24 December 2021

**Newcastle Grammar School - Park Campus (SSD-13895306)
Response to Submissions**

ATTACHMENT 1 – KEY ISSUES

STAGE 01 COMPLETE

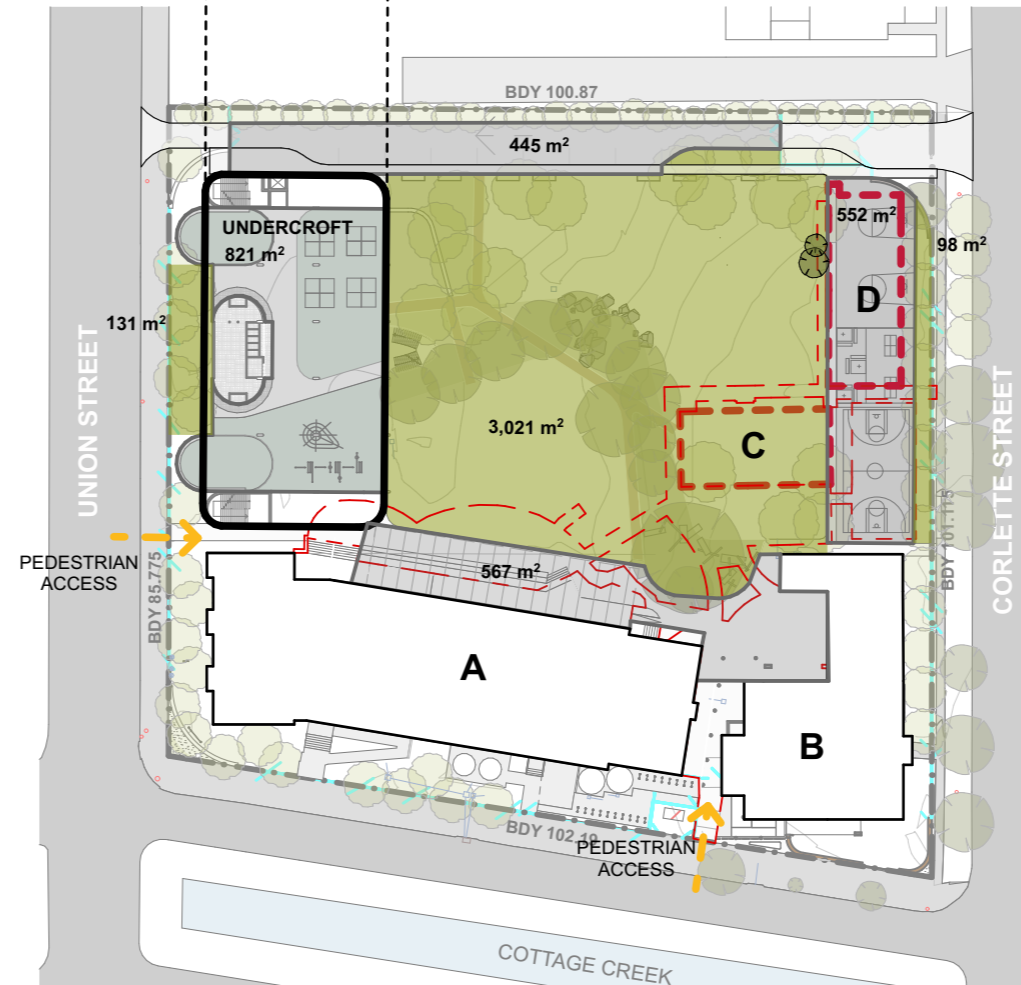
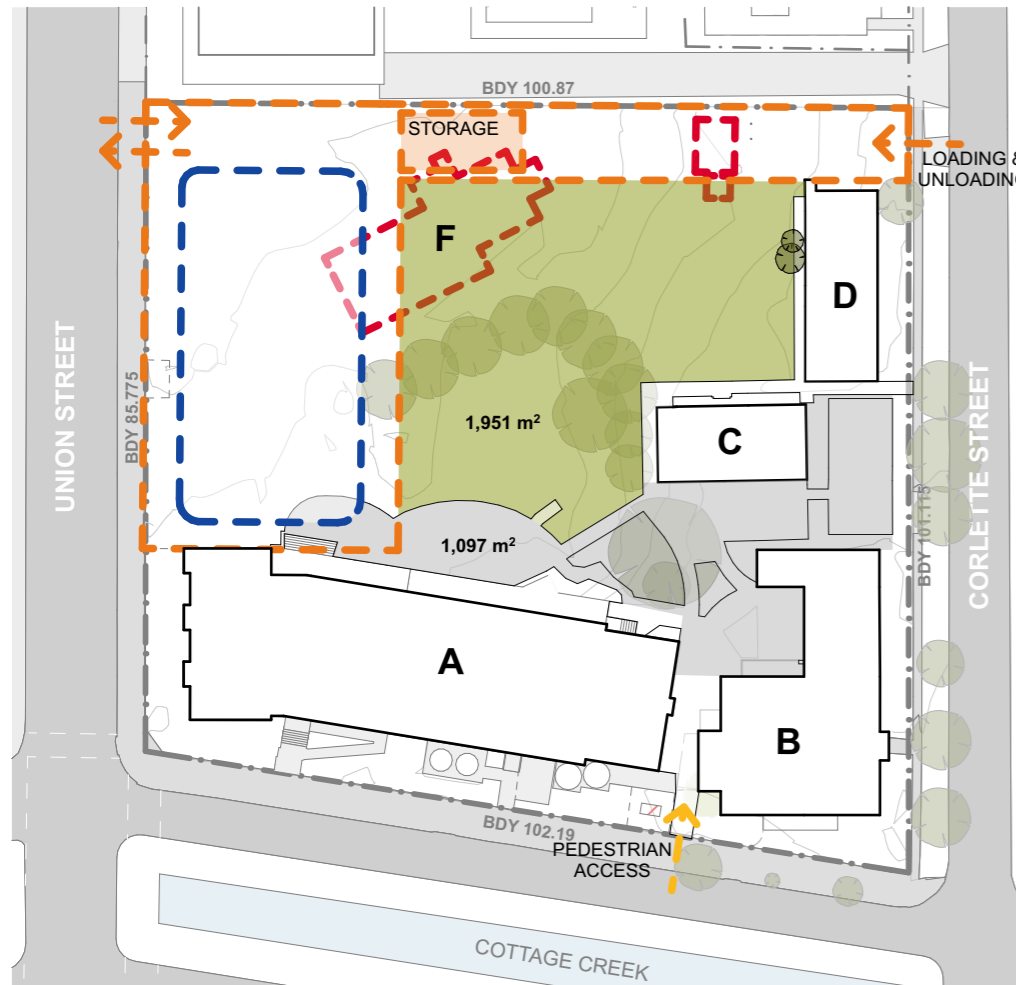
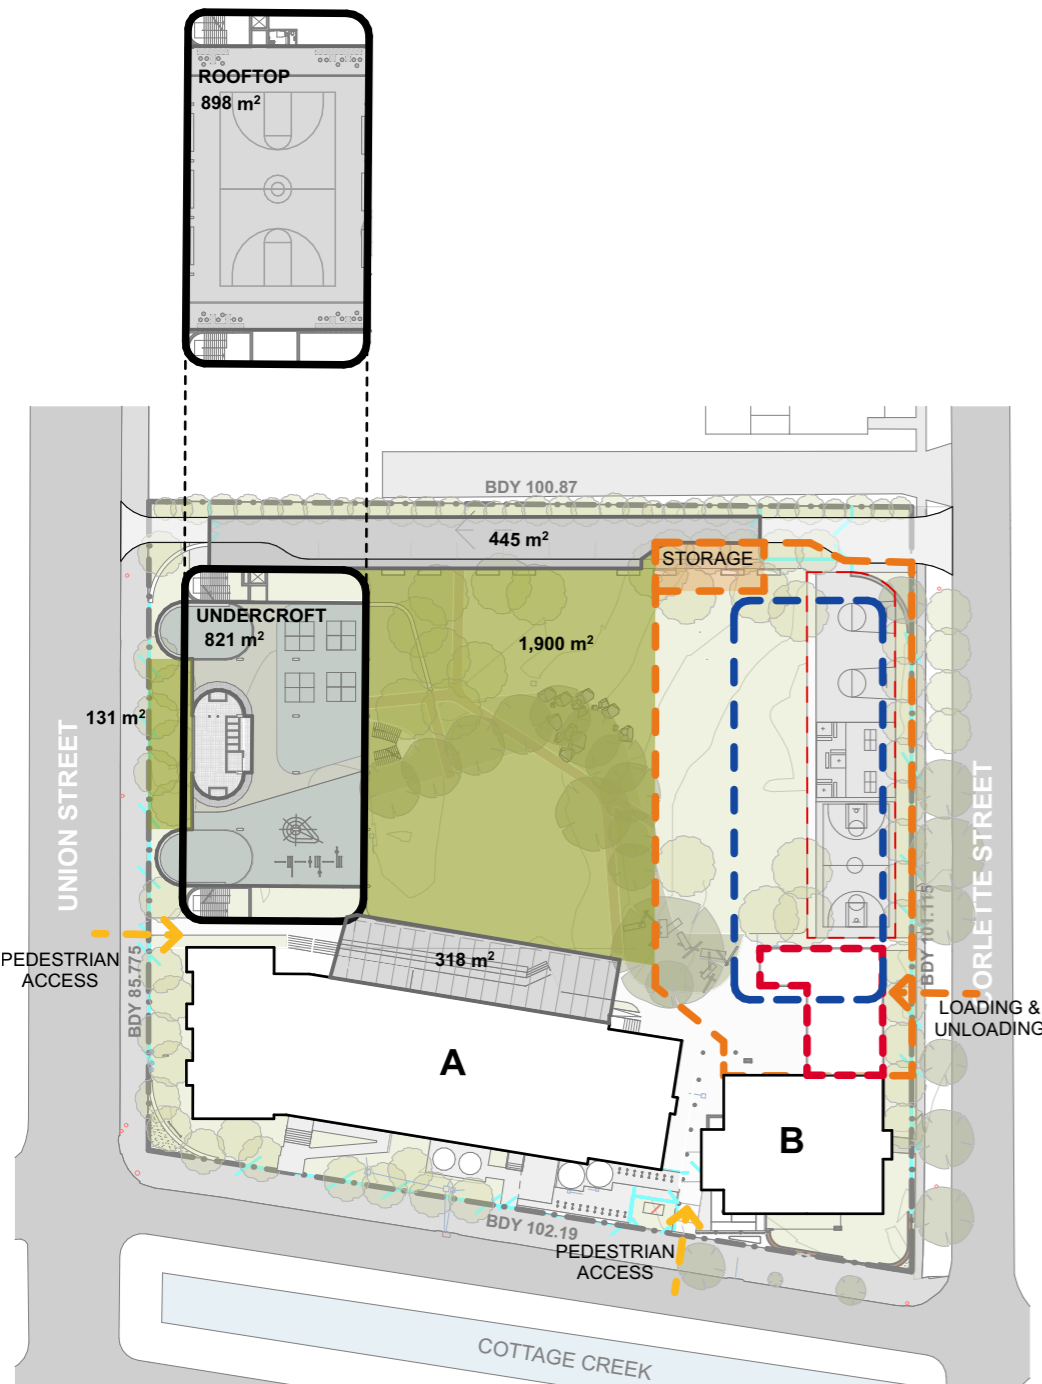
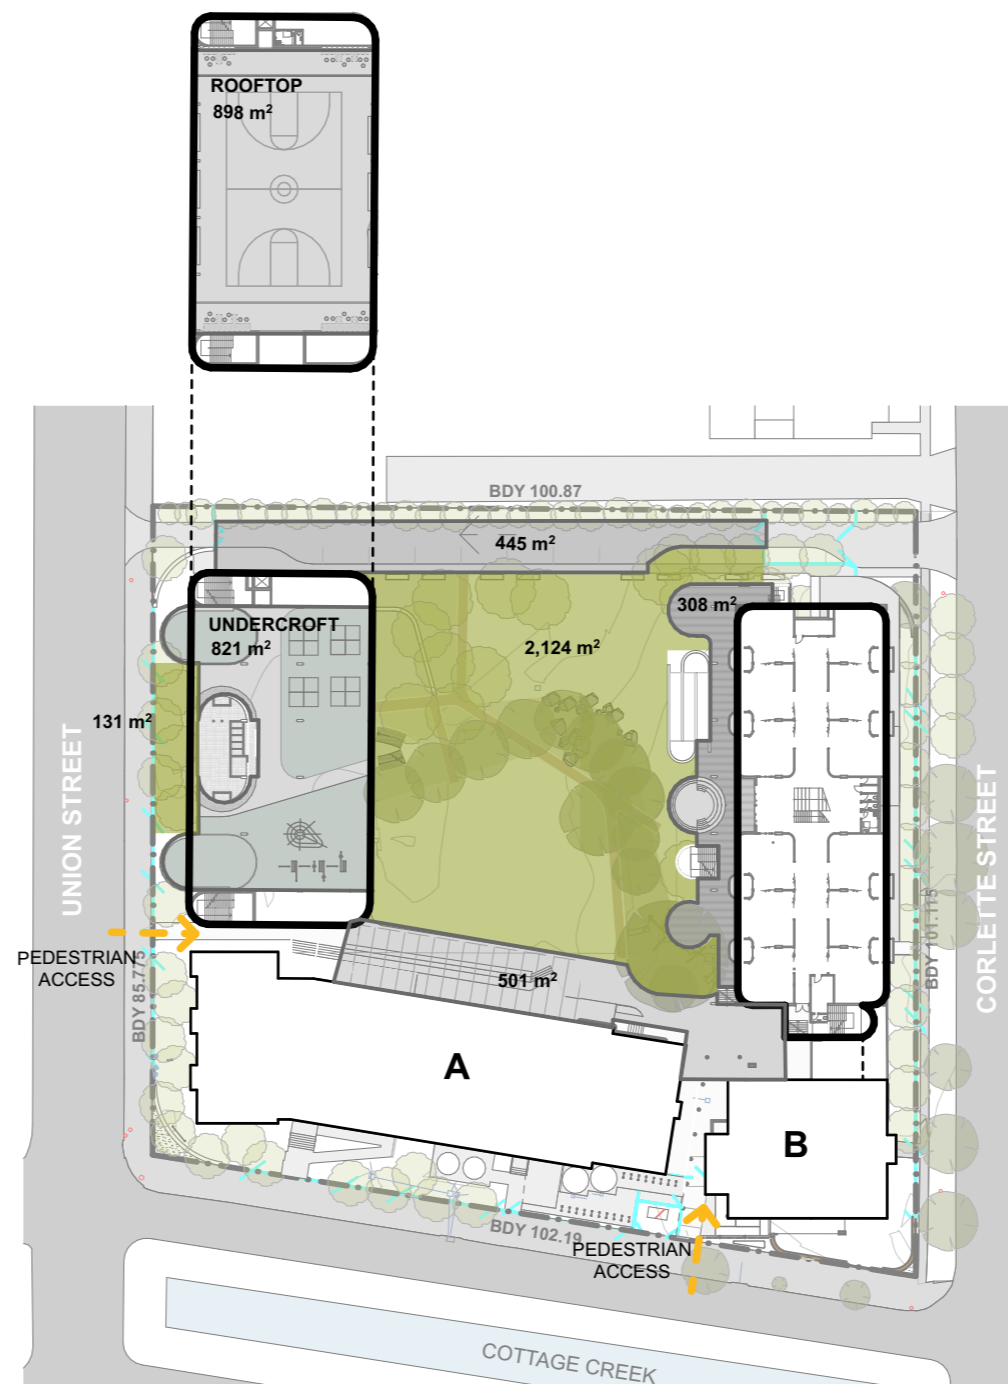
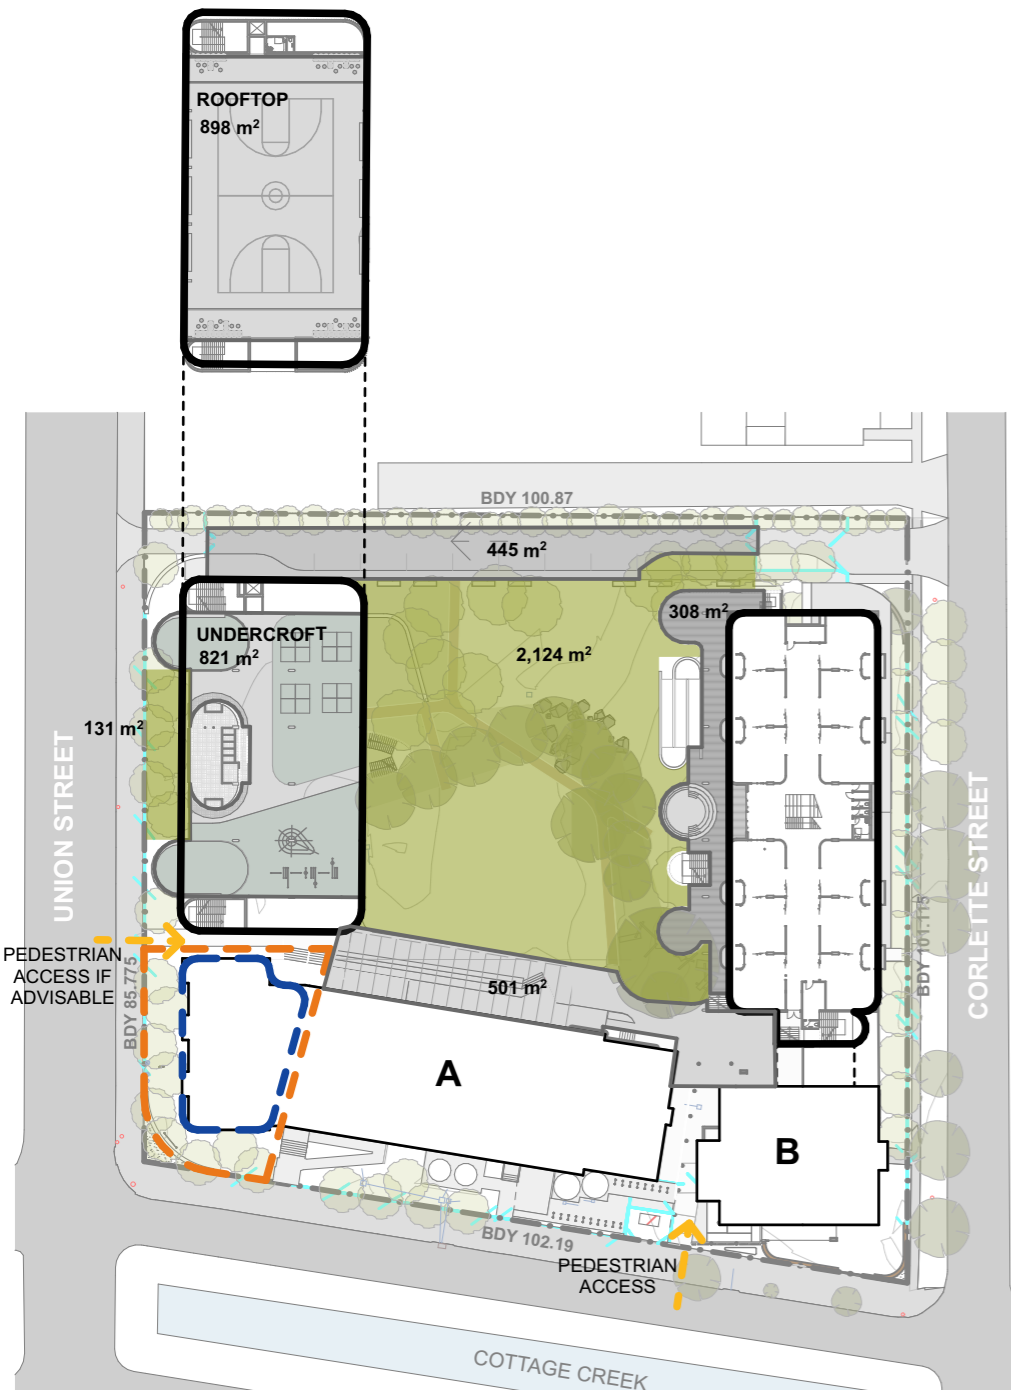
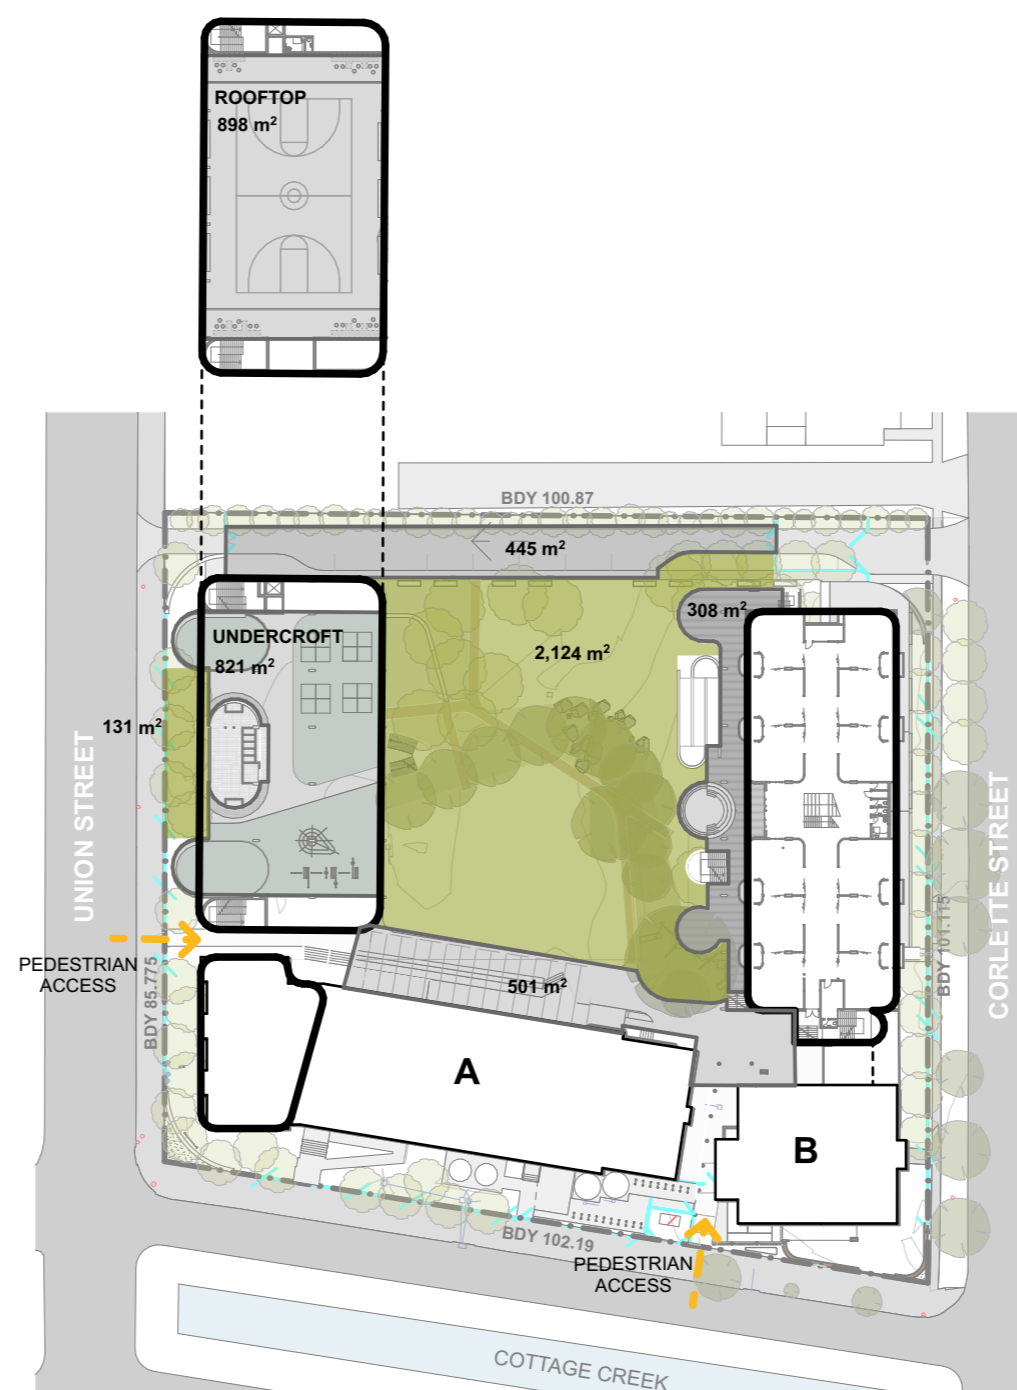
18. Provide details on the numerical amount of play area per student throughout the various stages of development.
